Application no: **3/2020/0066**

Address: **Green Beech Higher Commons Lane Mellor Brook Blackburn BB2 7PS**

Proposal: **Proposed first floor extension and alterations to existing bungalow to include new mono pitched single storey roof to rear, flat roof entrance canopy and single storey hipped roof to the side. Resubmission of application 3/2019/0861**

GROUND FLOOR PLAN AS PROPOSED

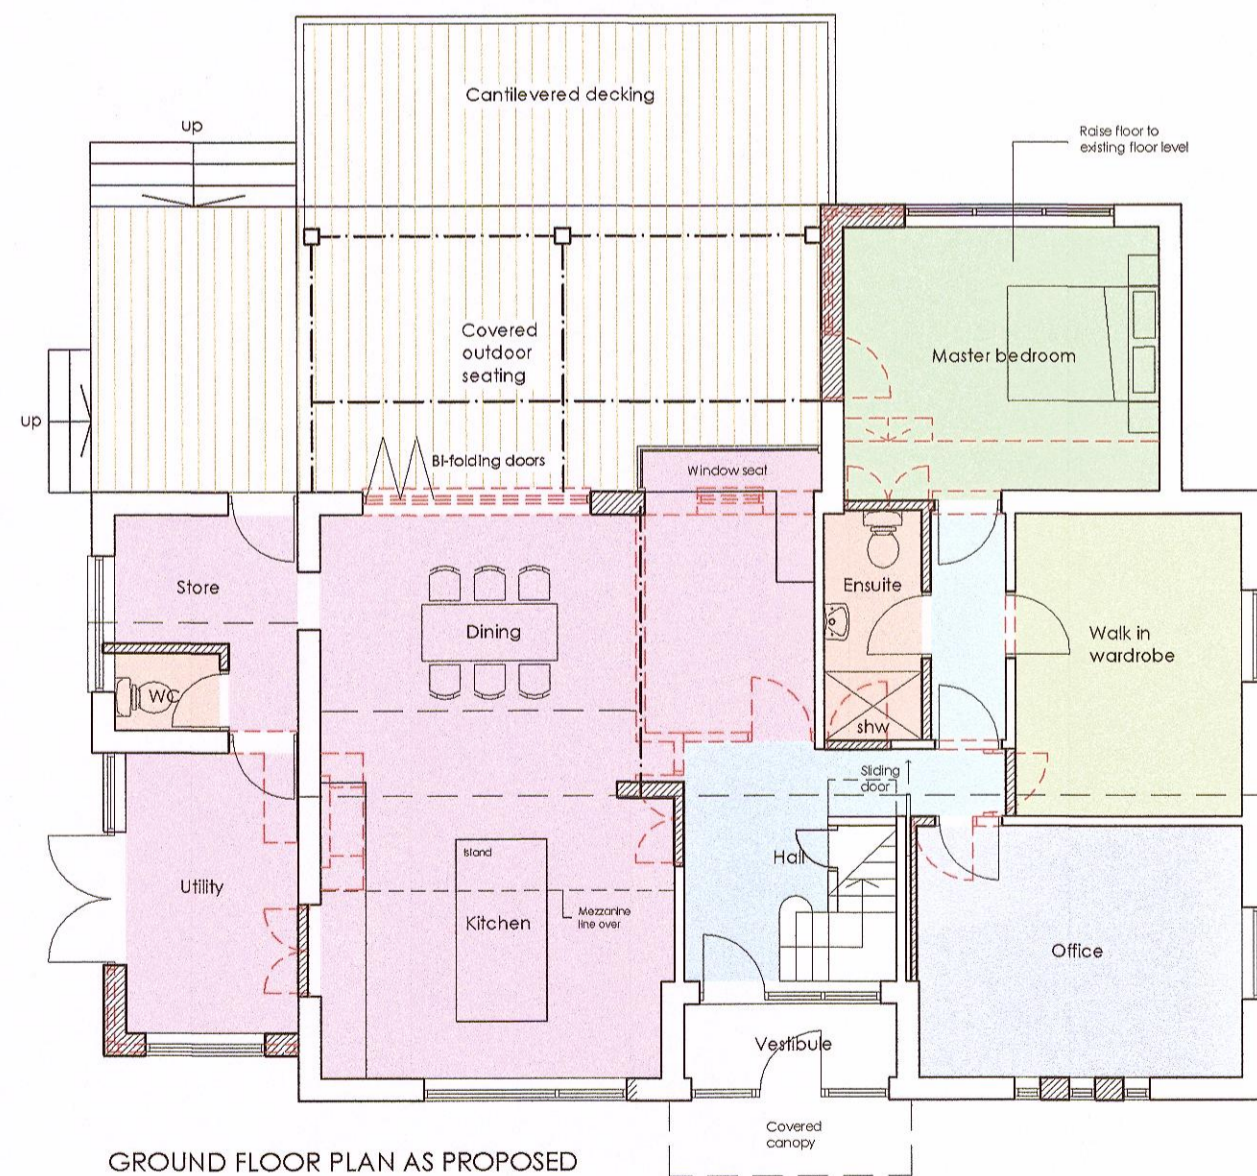
The parking provision is to be retained at two parking spaces as a result of the proposal, which can both be sufficiently accommodated for within the curtilage of the property whilst also providing adequate manoeuvrability for vehicles to enter and leave the driveway in a forward gear.

The first 5m of the driveway is to be bound with an approved surface material whilst the access point is to be widened with the existing boundary wall to either side of the access being slightly repositioned to aid visibility.

Higher Commons Lane is subject to a speed limit of 30mph and requires visibility splays of 2.4m x 43m. The road is also used as a through route to a local primary school and therefore the required visibility splays must be maintained to a height no greater than 1m in perpetuity of the development proposal.

Should access gate be positioned at the access point, then they should open into the site and not into the carriageway to prevent vehicles stopping and waiting on Higher Commons Lane.
